Please ask for: Nicola Moore
Email: nicola.moore@arun.gov.uk
Telephone: Ext 37944
Our Ref: AW/84/20/CLP
Your Ref:
Date: 30th March 2020

Lawful Development Certificate for a Proposed Use or Development

Development: Lawful development certificate for a proposed single storey rear extension, internal alterations and replacement roof window
Location: 18 Chawkmare Coppice Aldwick PO21 3SA

PROPOSED NORTH WEST ELEVATION @ 1:100

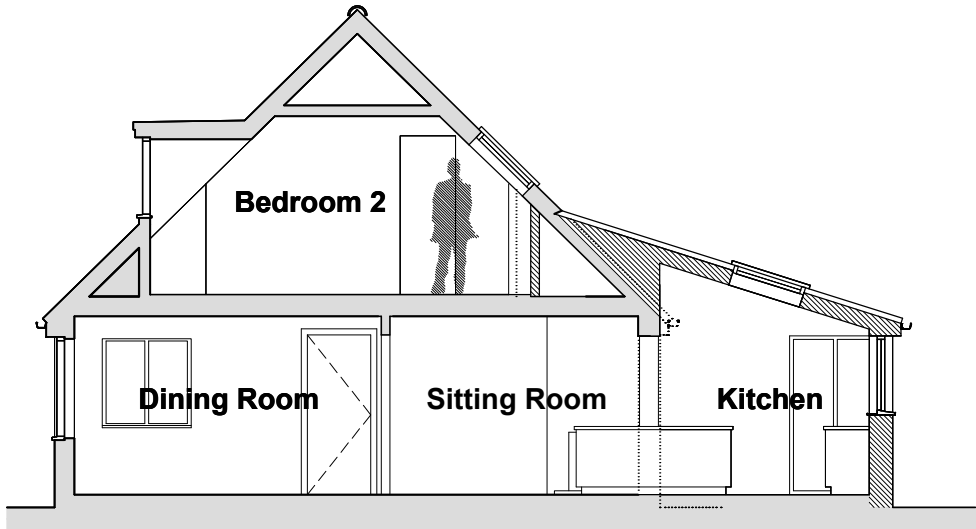
The North West existing and proposed elevations show a window on the garage, but this is not shown on the floor plans. Please amend accordingly and re submit.

PROPOSED NORTH EAST ELEVATION @ 1:100

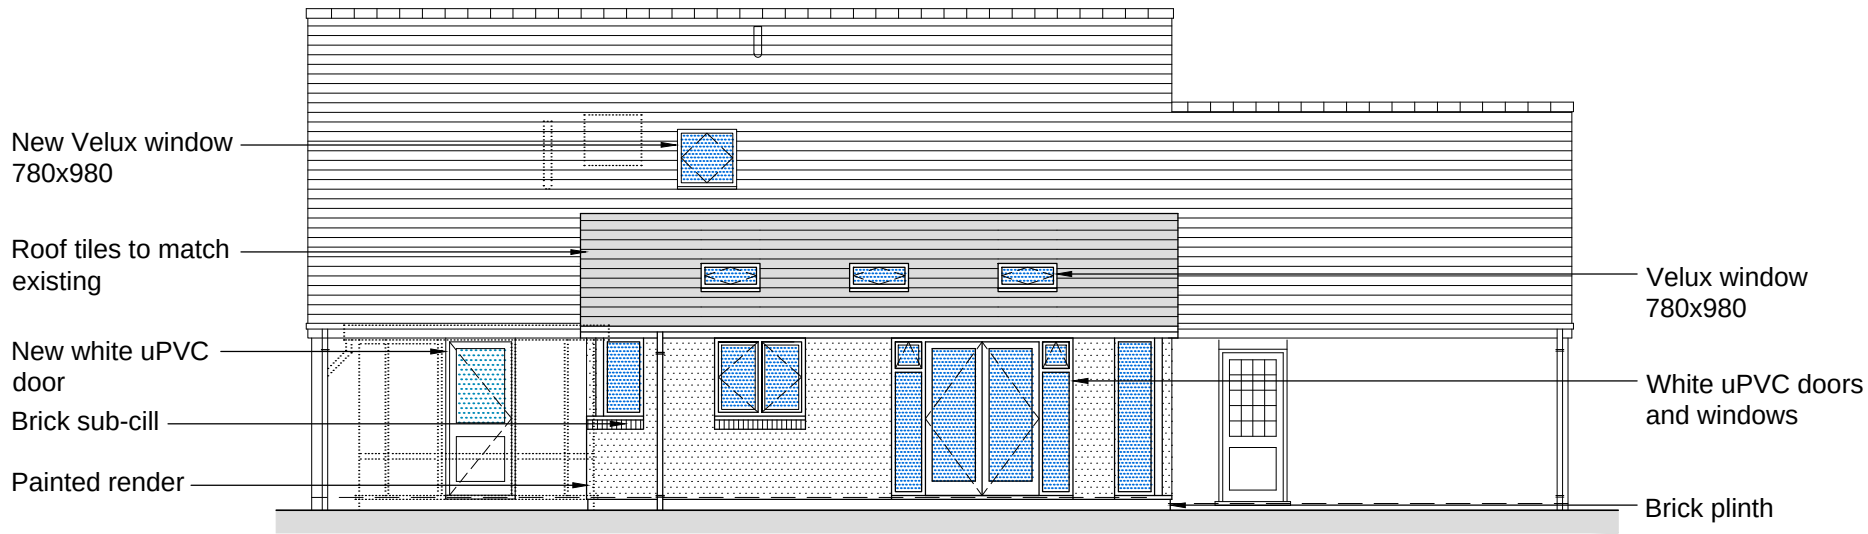
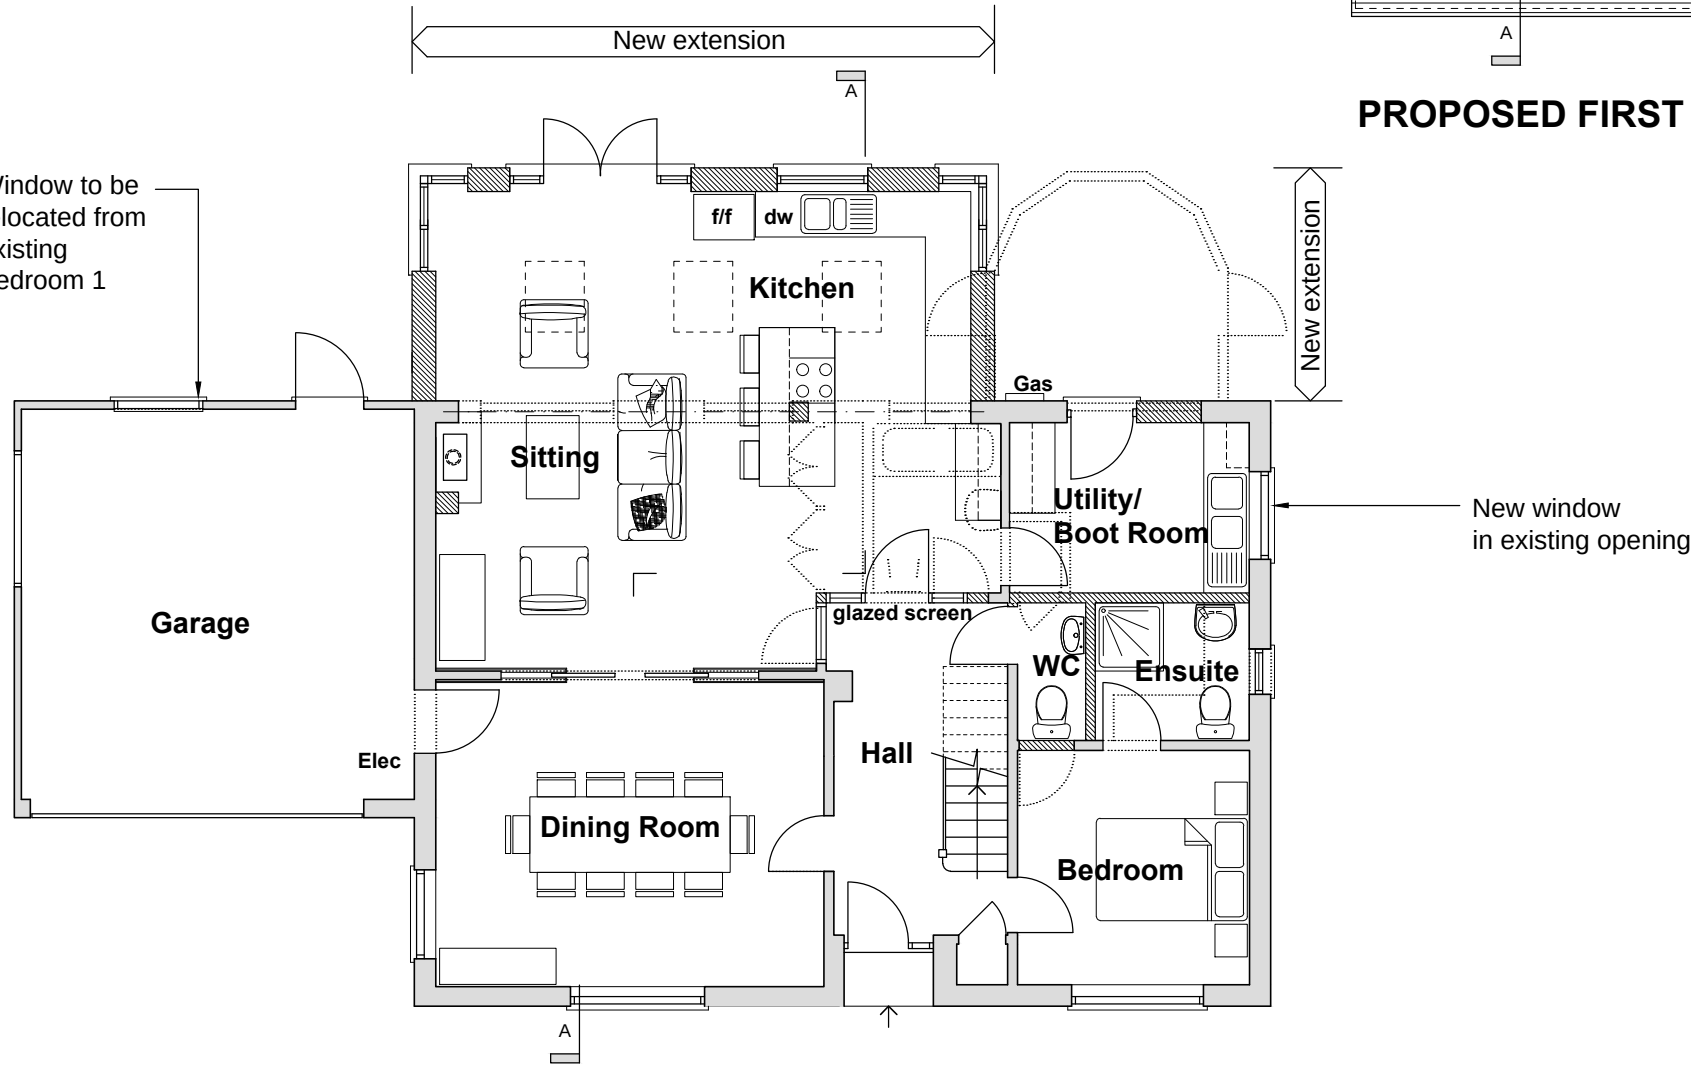
The North East floor plan shows appears to show a window in the garage, but not on the elevation. Please amend accordingly and re submit.

PROPOSED BLOCK PLAN @ 1:200

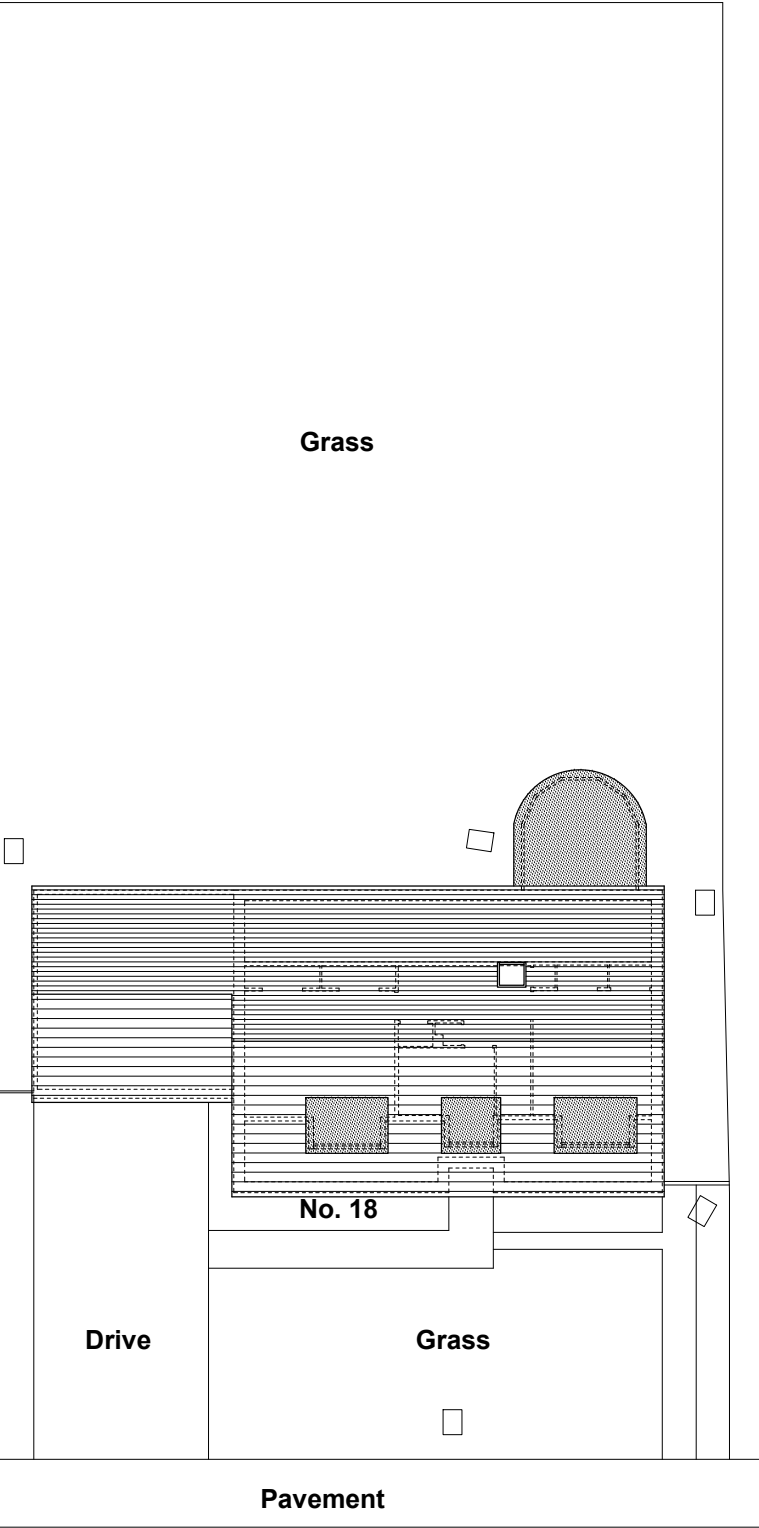
Please provide the distances of the development from the boundaries.
